Planning Inspectorate Ref:
EN010112

Conwy County Borough Council Ref:
ENQ/31314

**Application by Awel y Môr Offshore Wind Farm Limited for an Order Granting
Development Consent for the Awel y Môr Offshore Wind Farm project**

Written Representation by Conwy County Borough Council

This image provides landscape and visual context only

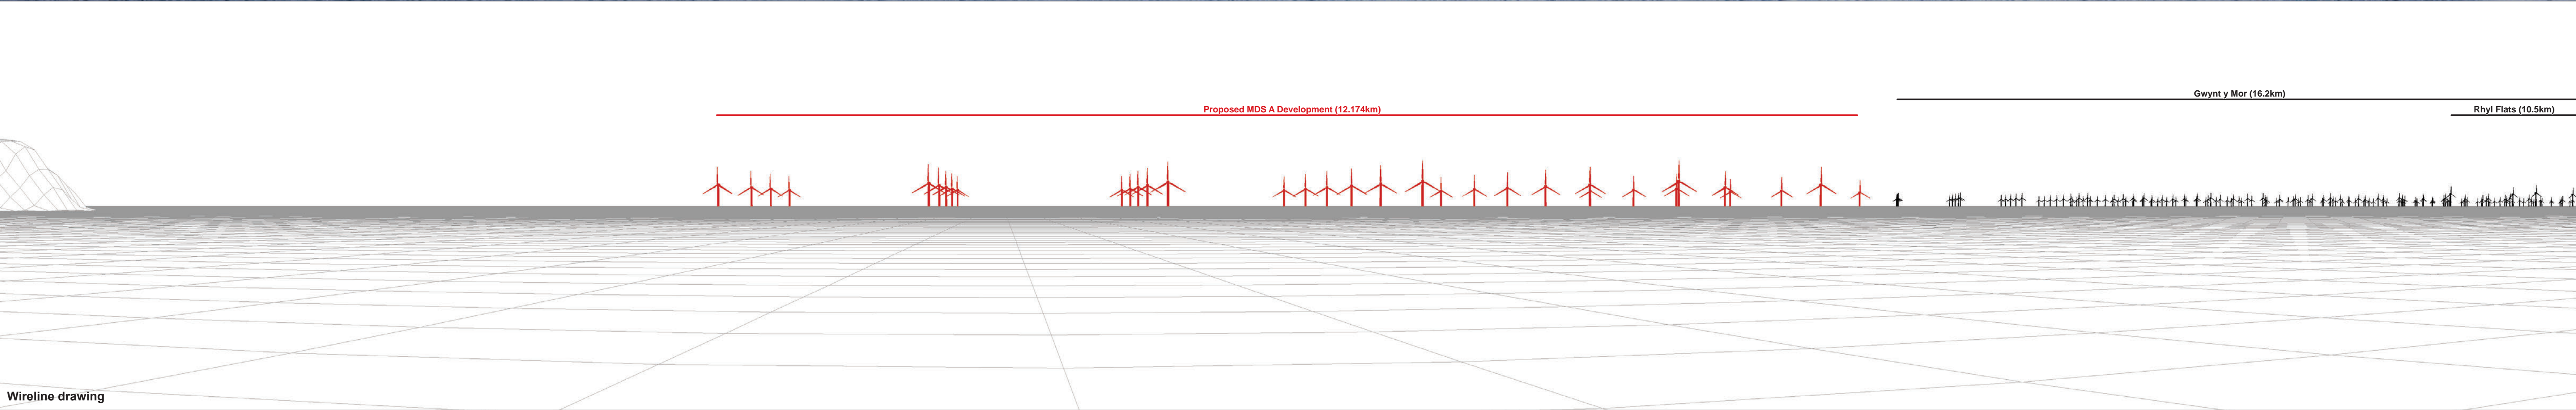
Figure 84c and 84h: Llandudno Promenade near Venue Cymru (12.174km)
